# COUNTY COUNCIL'S RESPONSE TO CONSULTATION ON THE FOLLOWING DEVELOPMENT PROPOSAL

**Application No:** 19/02708/OUT

**Proposal:** Outline:- Provide new employment units comprising B1 (Business), B2 (General Industrial), B8 (Storage) and DI (Education) uses with ancillary offices, storage, display and sales, with all matters reserved except for access

**Location:** Bicester Heritage, Buckingham Road, Bicester

Figure 37. Access and Movement Diagram (not to scale)

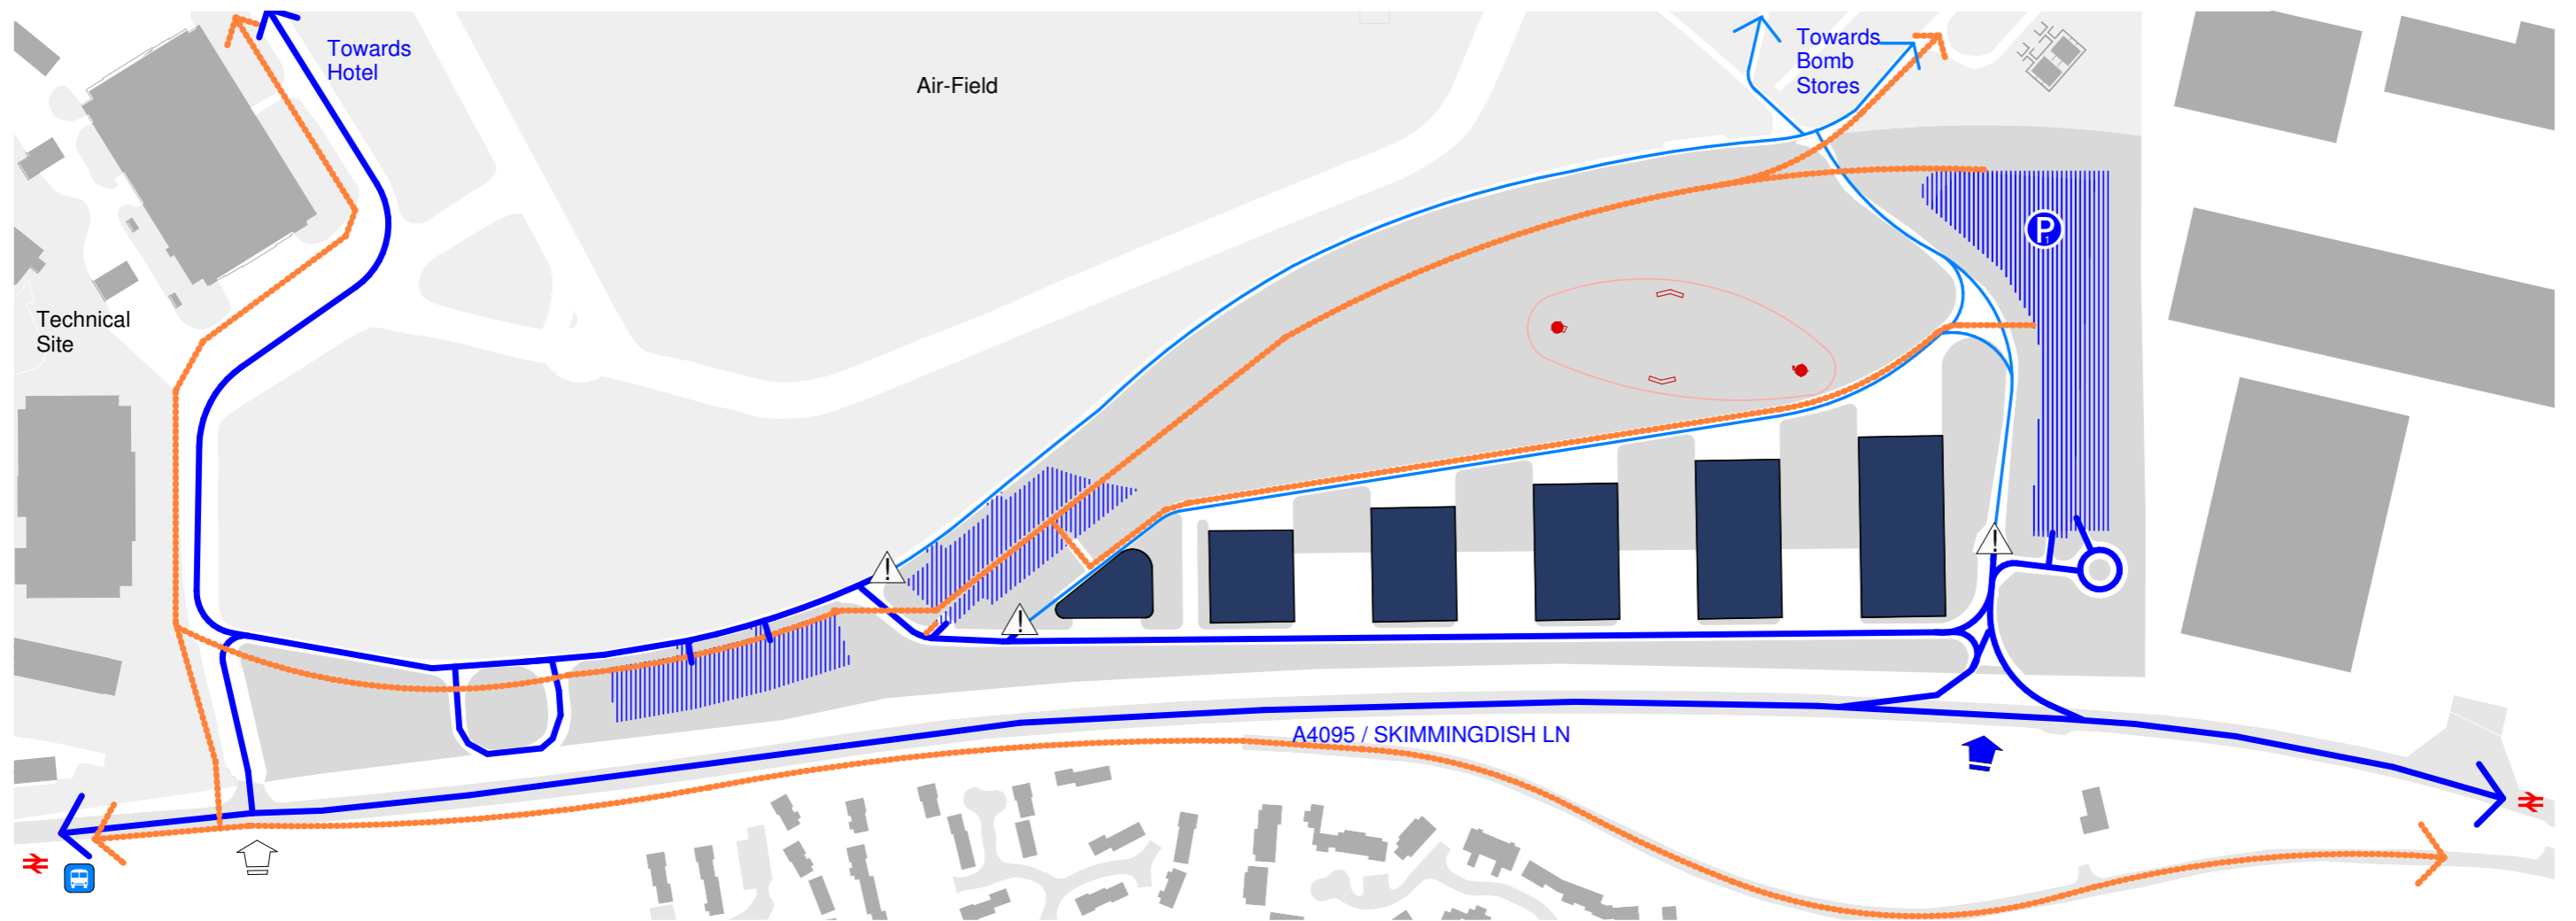
The TA sets out that a new vehicle access is to be created at the southeast corner of the site from Skimmingdish Lane. This is to be the main vehicle access to the FAST development. The access is to include a ghost right-turn island and allow all movements into the site. The access will prohibit vehicles leaving the site from turning right across Skimmingdish Lane by deflecting traffic using a splitter island and road markings, meaning that all traffic leaving the site and needing to travel west on Skimmingdish Lane will be required to turn at the Launton Road / Care Home / Skimmingdish Lane roundabout. This impact has been taken into account in the modelling of that junction (see ‘Traffic Impact’ section below). A Traffic Regulation Order would be required in order to legally prohibit right-turns from the site onto Skimmingdish Lane.

It is intended that this access is to be controlled and therefore some form of gate or barrier would be required. Given the speed and nature of Skimmingdish Lane it is vital that any such barrier is sufficiently located within the site to ensure that any waiting or queueing vehicles (including HGVs) do not obstruct the carriageway.

It is also proposed that the existing access which is currently used by the glider club will be retained and upgraded to a similar layout - enabling all movements to access the site and prohibiting right-turns from the site, a TRO would also be required for this site access. The TA sets out that this access is intended to be used by visitors to the wider masterplan site, along with vehicle access junctions along the Buckingham Road.

Throughout pre-app discussions the county council has stated that it considers that a new access from Skimmingdish Lane is unnecessary and that the existing gliding club access should be utilised for the development.

The TA sets out that the new access is required to separate staff and visitors to the FAST site from those visiting the wider masterplan site. The county council continues to consider that this could be effectively managed from within the site, with many visitors to the wider masterplan site accessing the site from Buckingham Road in any event, and that the new separate access to the FAST development is not absolutely necessary. This is particularly the case given the strategic improvements identified for Skimmingdish Lane outlined in LTP4 policy BIC 1 (see section on Skimmingdish Lane below).
